15 August 2018

St Aloysius' College Limited  
c/o Bloompark Consulting  
Suite 3 Ground Floor 41 McLaren St  
NORTH SYDNEY NSW 2060

### **St Aloysius College SSDA Revised Noise Impact Assessment**

ROOF LEVEL LANDSCAPE PLAN

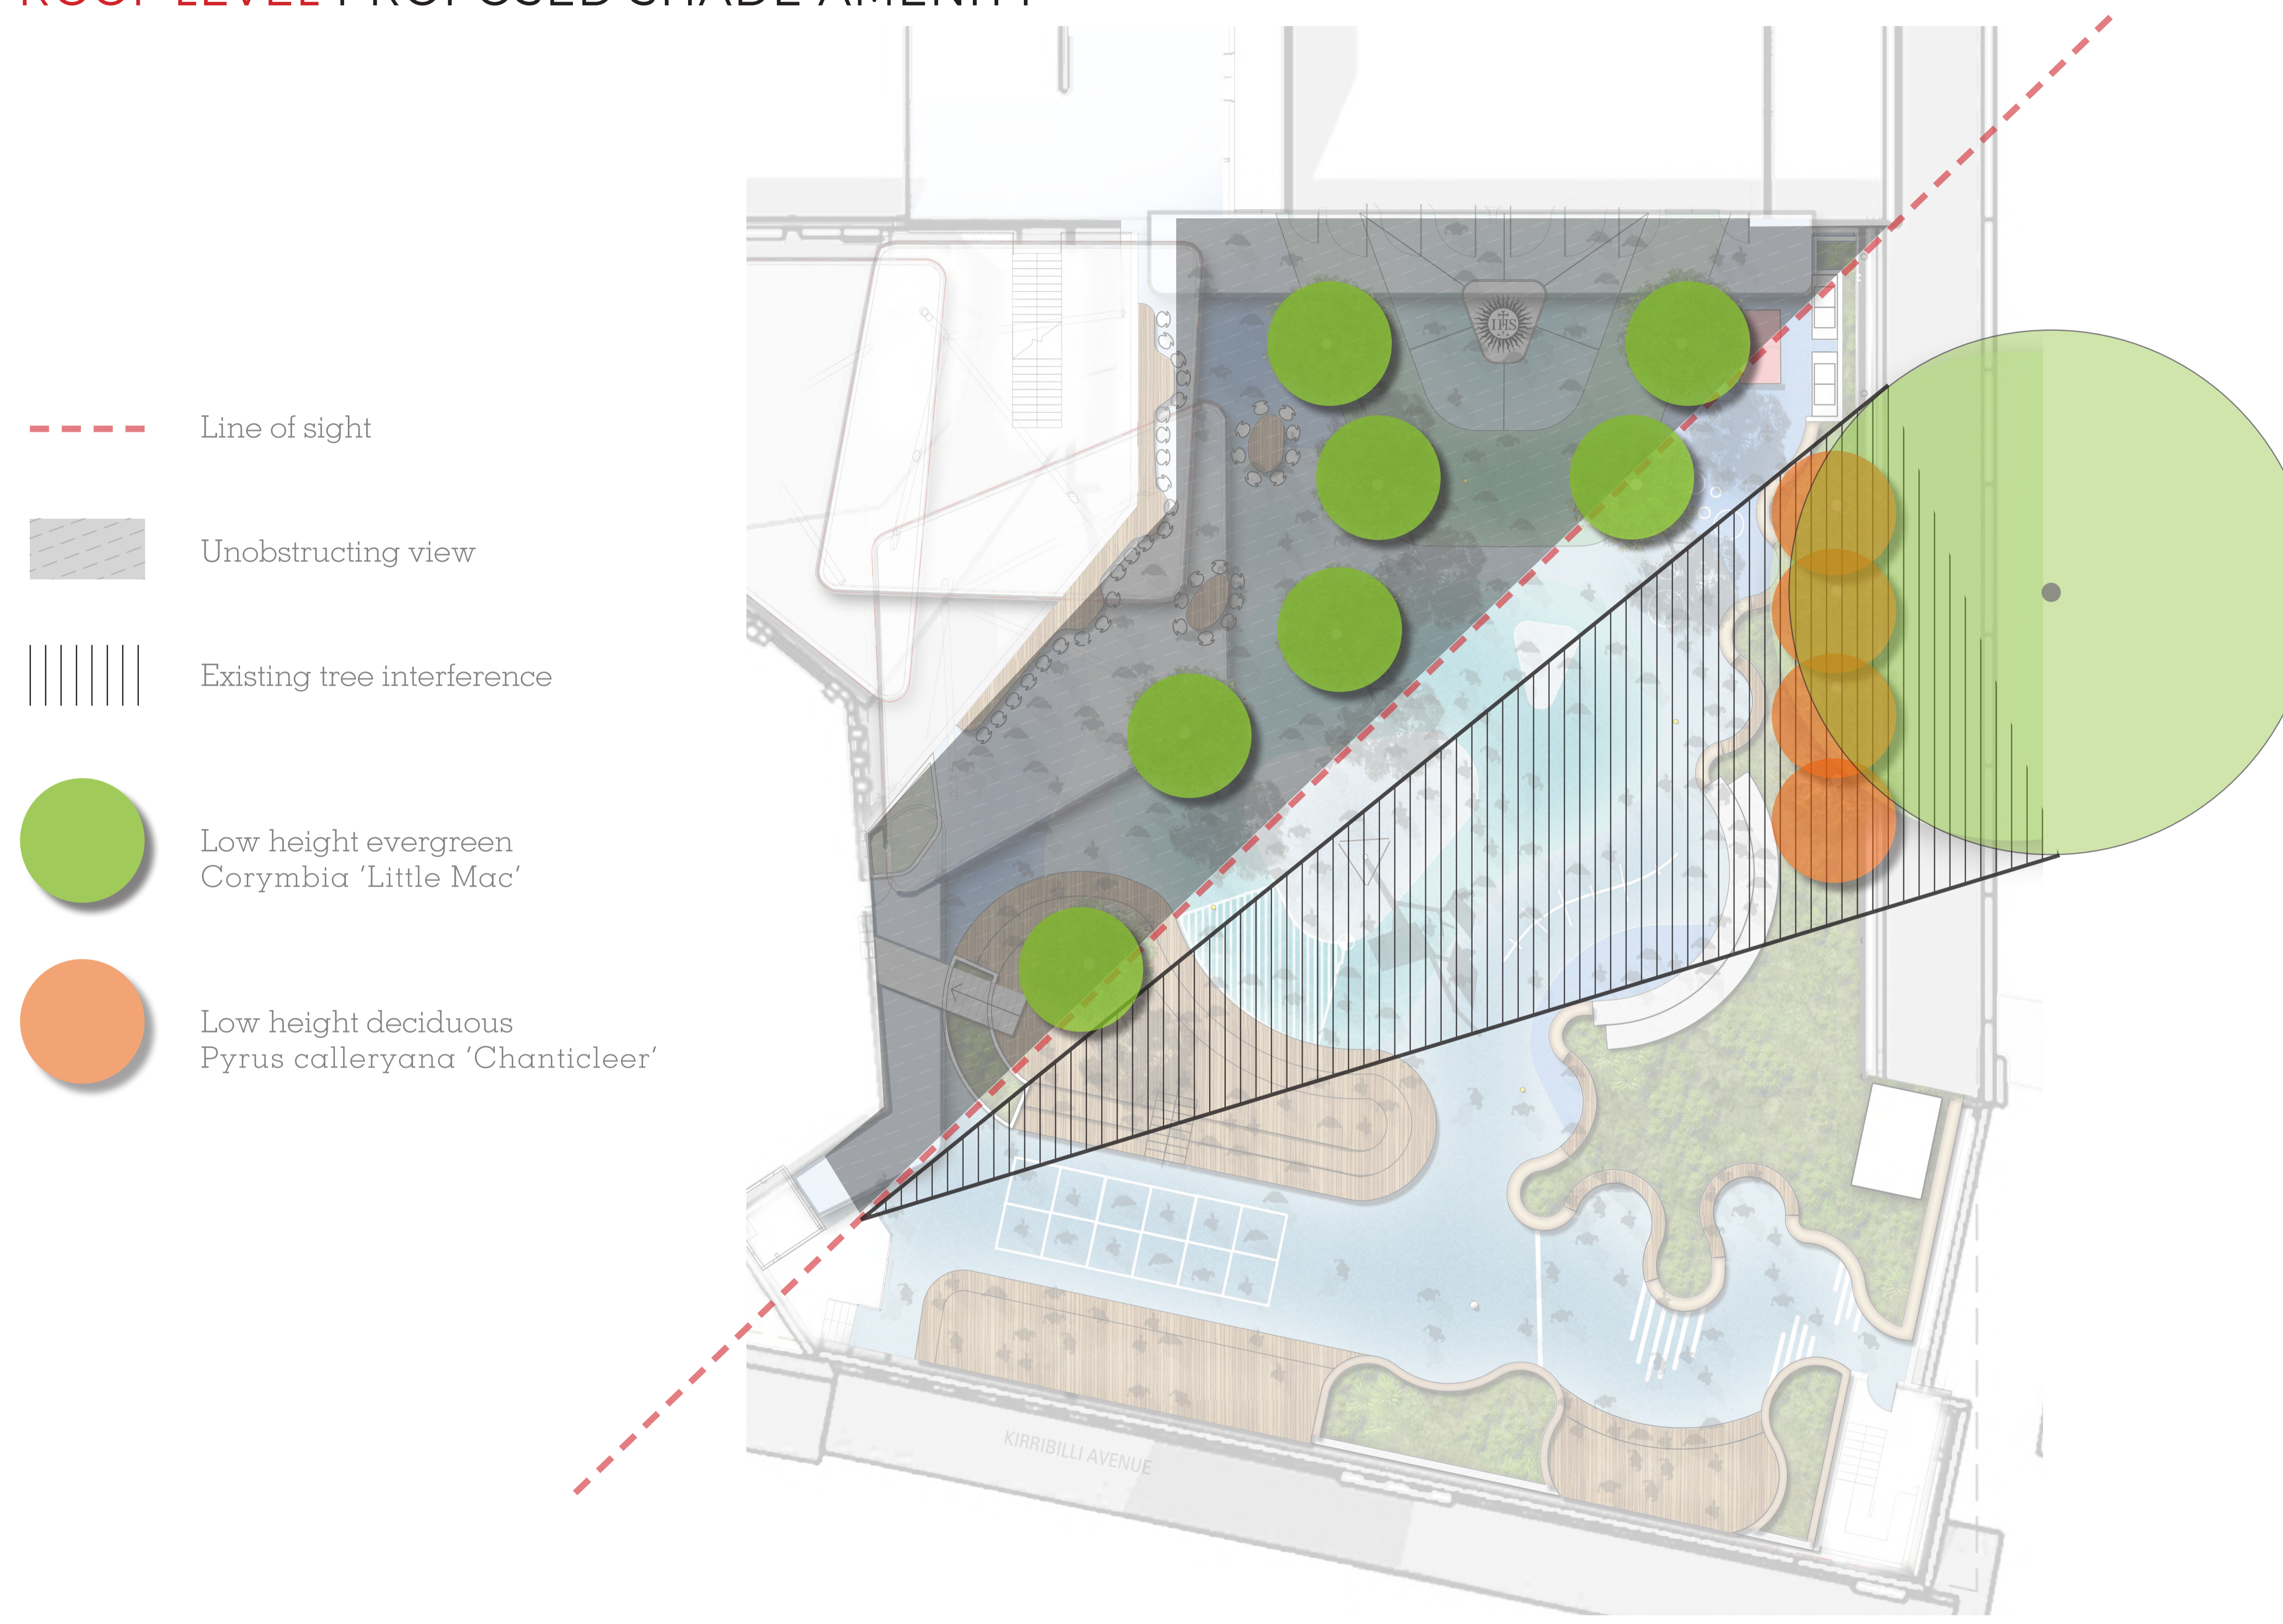
- *The NIA must be updated to:*
  - *Confirm that the assessment has considered the proposed hard surface materials on the rooftop terrace as set out in the Landscape Plan submitted with the EIS; – Confirm that is the case (as it was in original report). Paragraph added to Section 5.1.1.2*
  - *Include conclusions in relation to mechanical plant emissions; and – Added Section 5.1.4*
  - *Address the updated Noise Policy for Industry 2017. – Revised Section 4.1 and all subsequent criteria accordingly*
- *Acoustic Impact of proposed mechanical plant, and proposed measures to mitigate. – Added Section 5.1.4*
